COUNTY COUNCIL'S RESPONSE TO CONSULTATION ON THE FOLLOWING DEVELOPMENT PROPOSAL

Application no: 25/01510/OUT

Proposal: Outline planning application for the erection of up to 500 dwellings and commercial floorspace (Use Class E) with associated access, open space and infrastructure - All Matters Reserved except for Access.

Location: Land South Of Perdiswell Farm, Shipton Road, Shipton On Cherwell

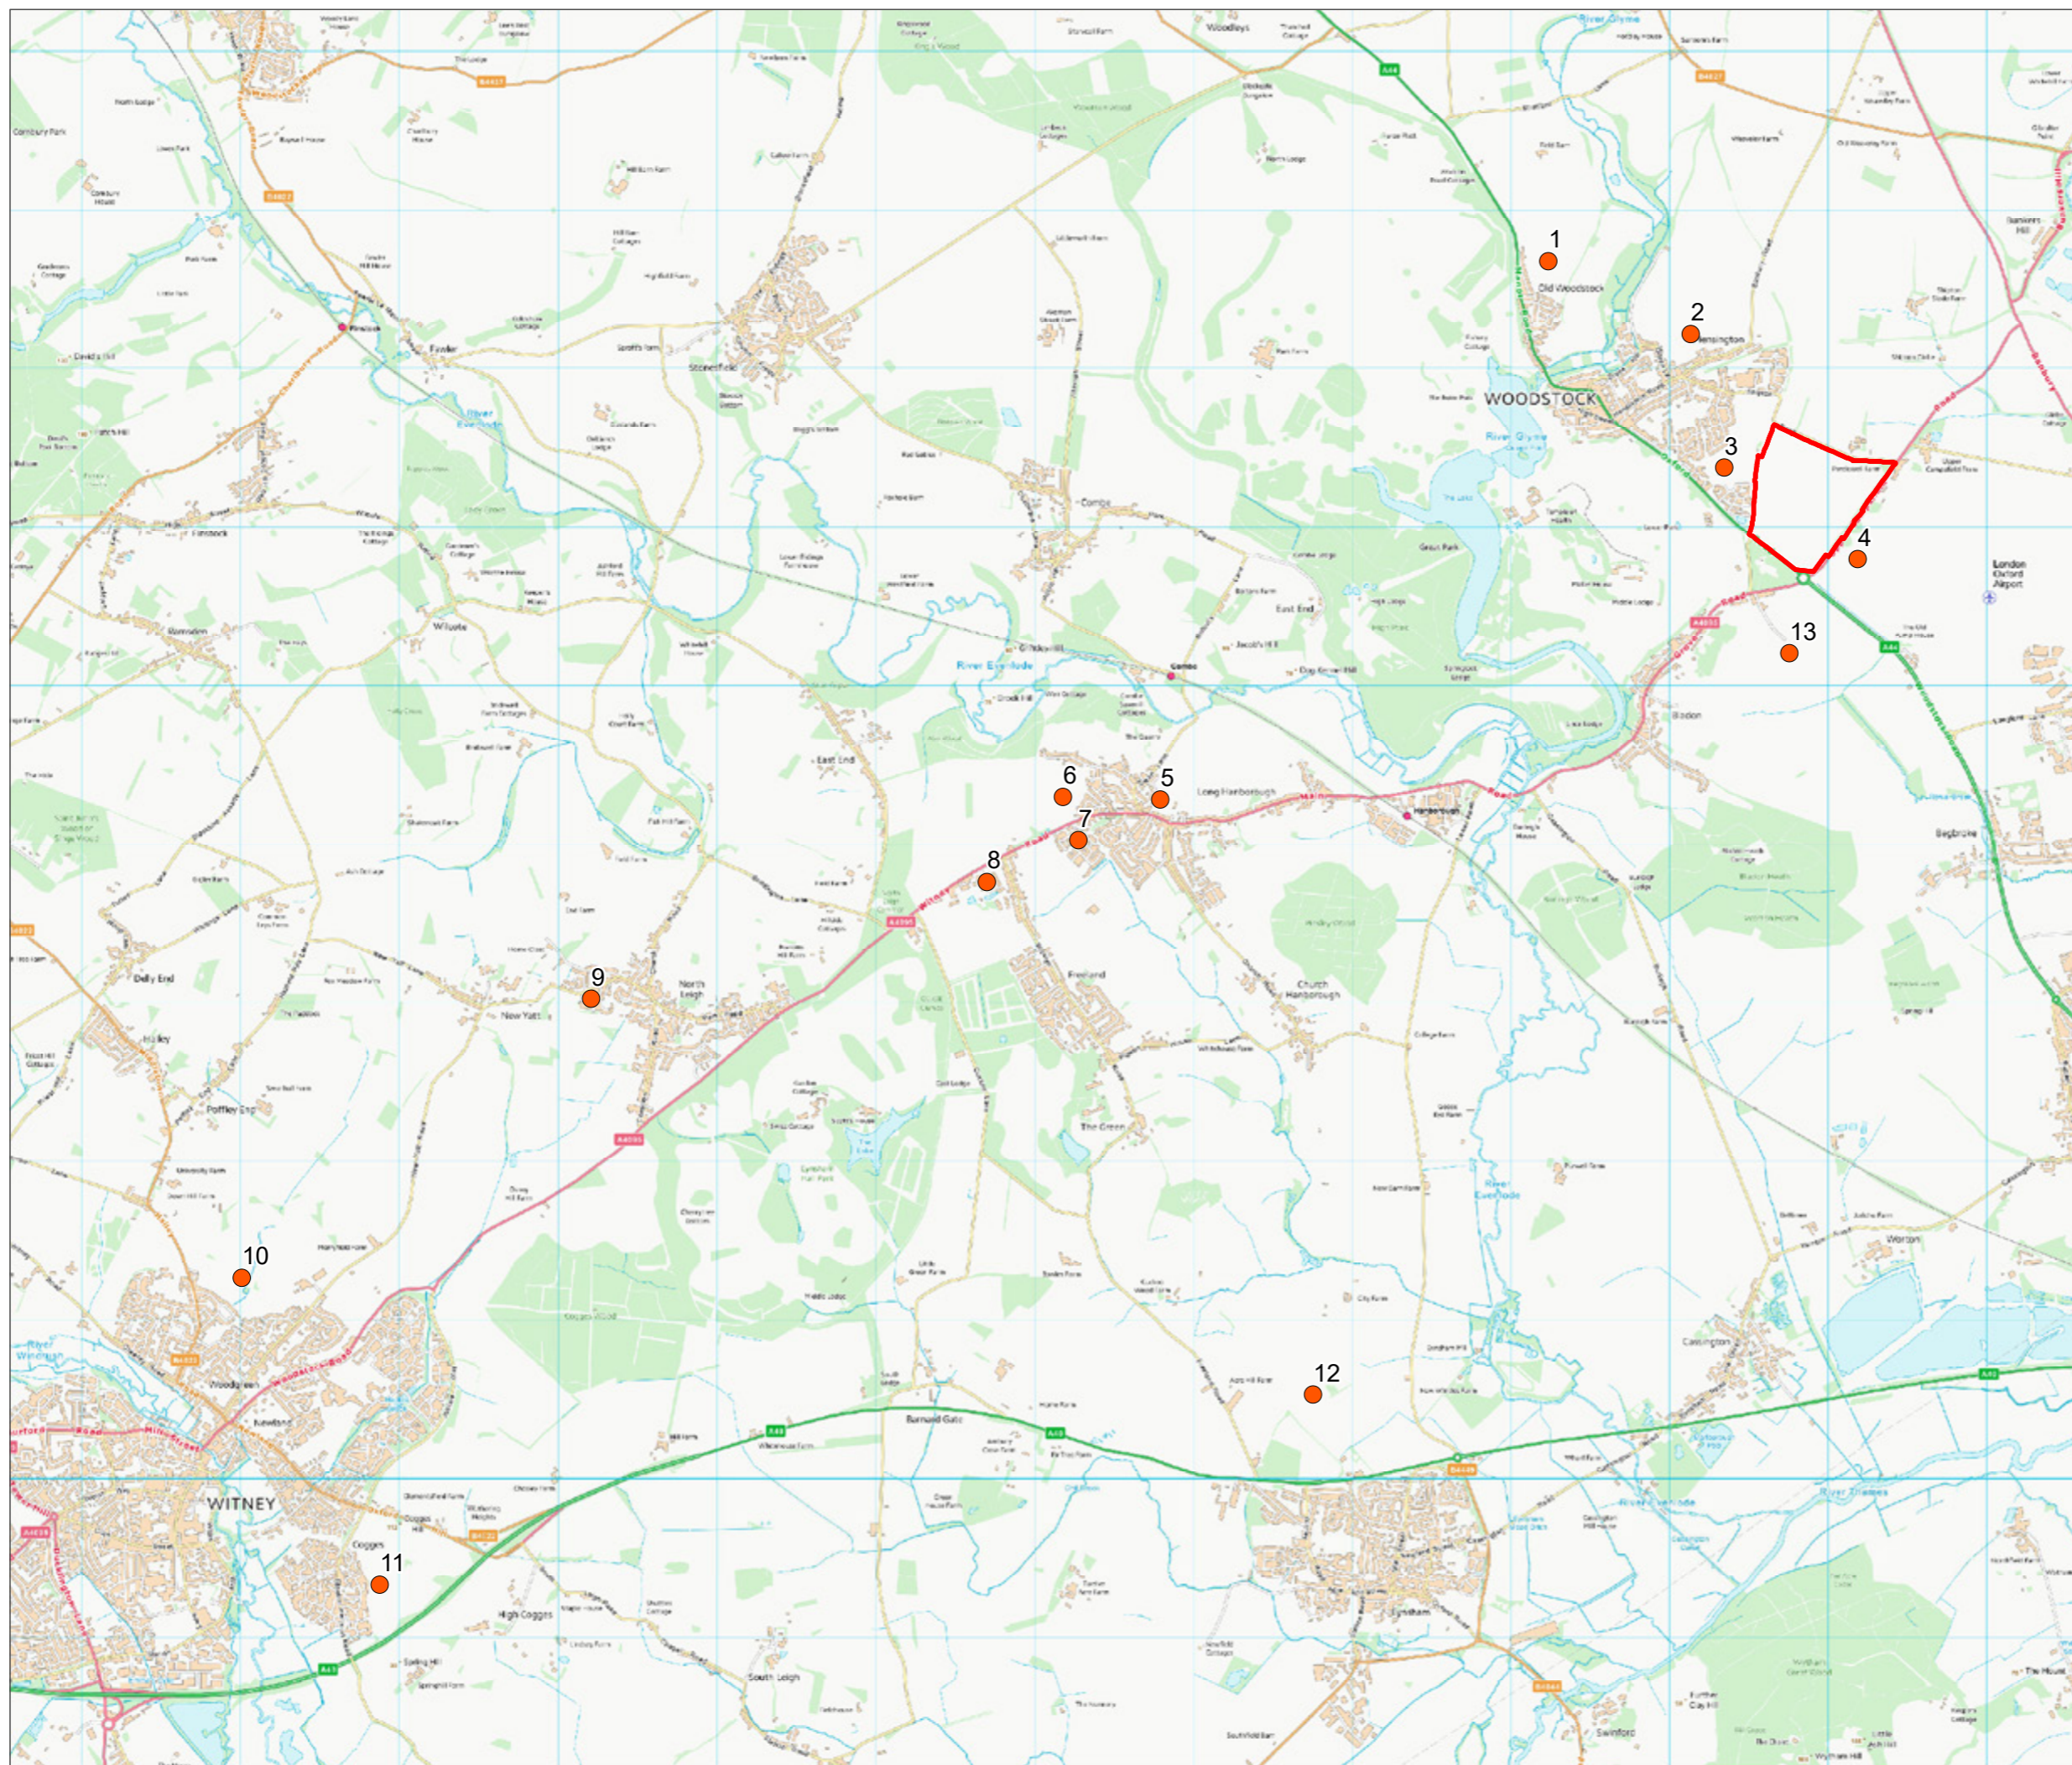
- The applicant is proposing to change the access to Park View into a pedestrian, cycle and bus only access.
- This is not acceptable as section 2.1 of the Oxfordshire Highways Design Guide states that development with more than 400 dwellings require more than one access.

Rather than providing a signalised junction, the applicant has now proposed to change this access into a pedestrian, cycle and bus only access.

This is not acceptable. Section 2.1 of the Oxfordshire Highways Design Guide states that up to 400 dwellings could be served by one access, while more than 400 dwellings must be served by more than one access. The applicant is therefore required to provide a scheme for signalisation of the Cowells Road /A44 junction.

The proposed link shown in the TAA is not a Public Right of Way or within adopted public highway. Although it has been included in the original Park View Access and Movement Parameter Plan, it is now understood that this land is not in the ownership of the park View applicants and they are not in a position to deliver the connection.

A connection at the north west corner of the application site to Shipton Road is therefore required and the submitted Access and Movement Parameter Plan needs to be amended to include this connection.
